19 December 2017

File No: R/2016/20/B  
Our Ref: 2017/621048

**Amended Concept Proposal for Cockle Bay Wharf (SSD 7684), 17-27 Wheat Road, Sydney**

future Town Hall Square - STEREOGRAPHIC MAPS

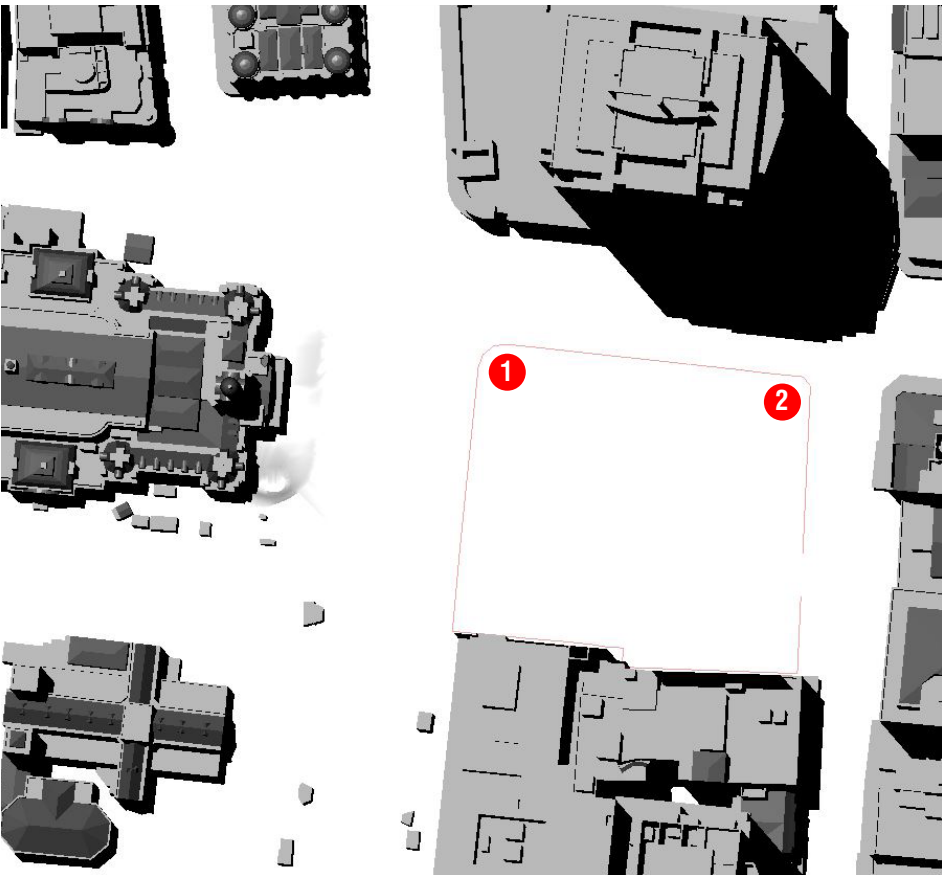
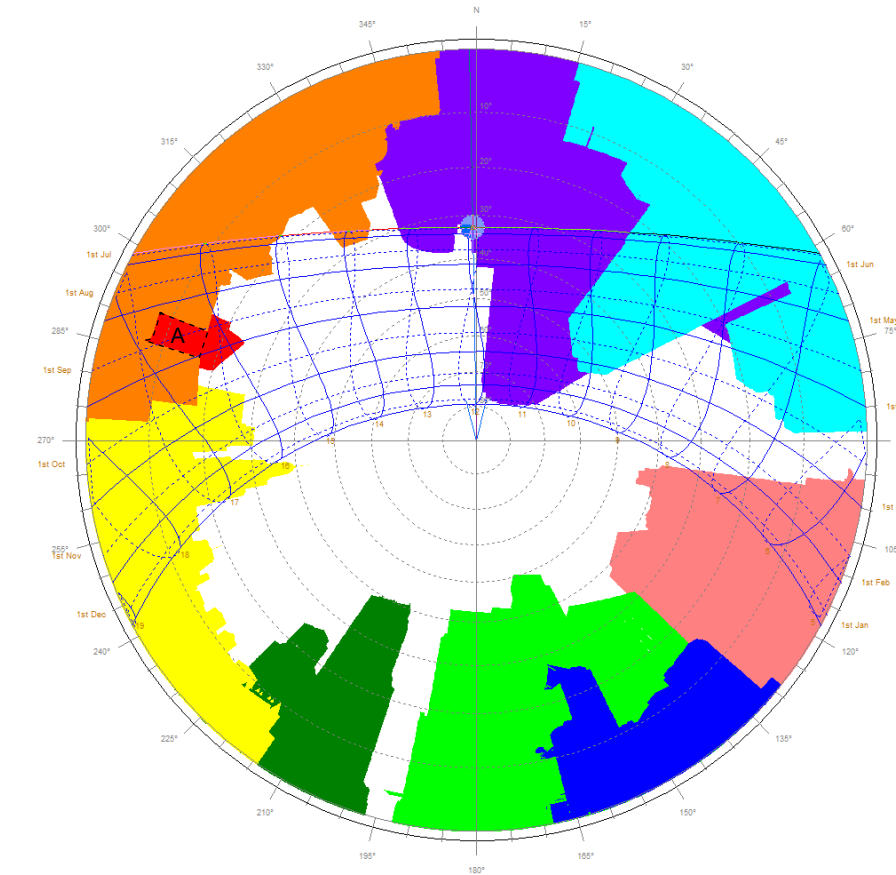
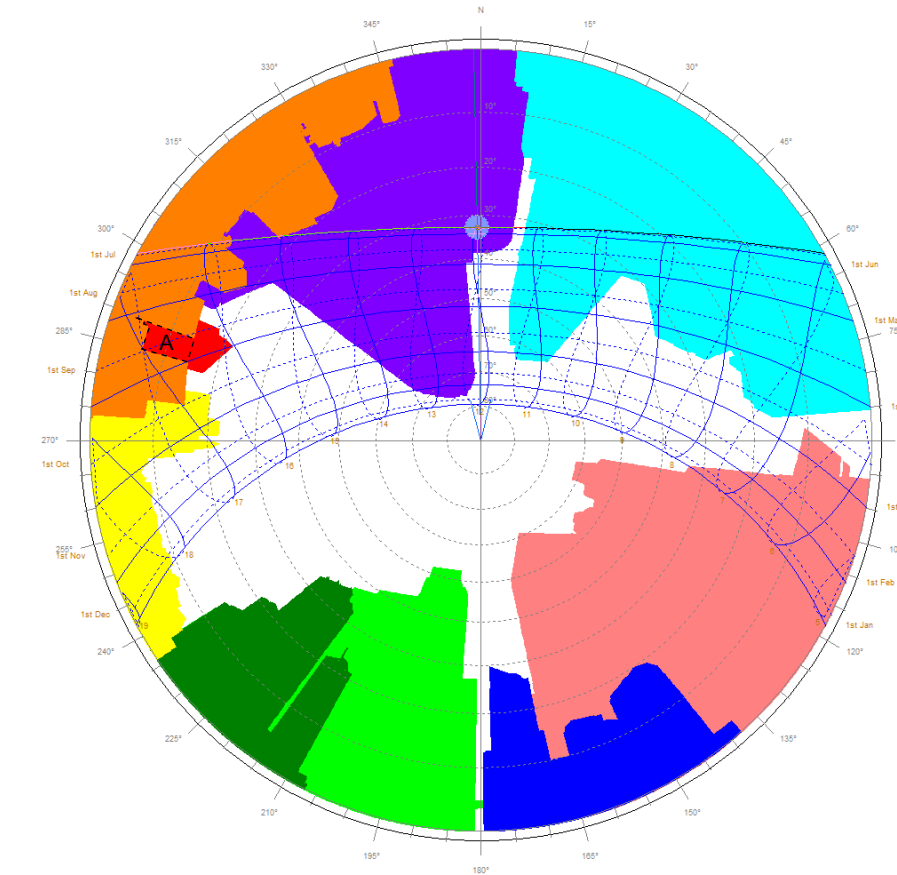
The stereographic maps provided at Attachment B detail the overshadowing impact of the proposed Concept Plan envelope on Future Town Hall Square which is protected by a proposed No Additional Overshadowing Control (at any time of year) under the Central Sydney Planning Framework. A stereographic map is a fish-eye view looking up at the sky from Future Town Hall Square – taken from 2 locations. The Concept Plan envelope (shown in red) appears in the left of the view. The blue date lines that run over it indicate the date range that Future Town Hall Square will be directly affected by the proposal.

The stereographic maps however do not include the approved and under construction hotel/serviced apartment development at 230 Sussex Street (corner of Sussex Street and Drutt Place). The bulk of this approved building is shown marked "A" and a black hatched on both stereographic maps.

Taking 230 Sussex Street into consideration, the additional overshadowing created by the proposed Concept Plan is still significant with overshadowing from September 1 to 23 and March 21 to April 15.

Without amendment the proposal is inconsistent with to Planning Priority E6, and the public interest and cannot be supported by the City.
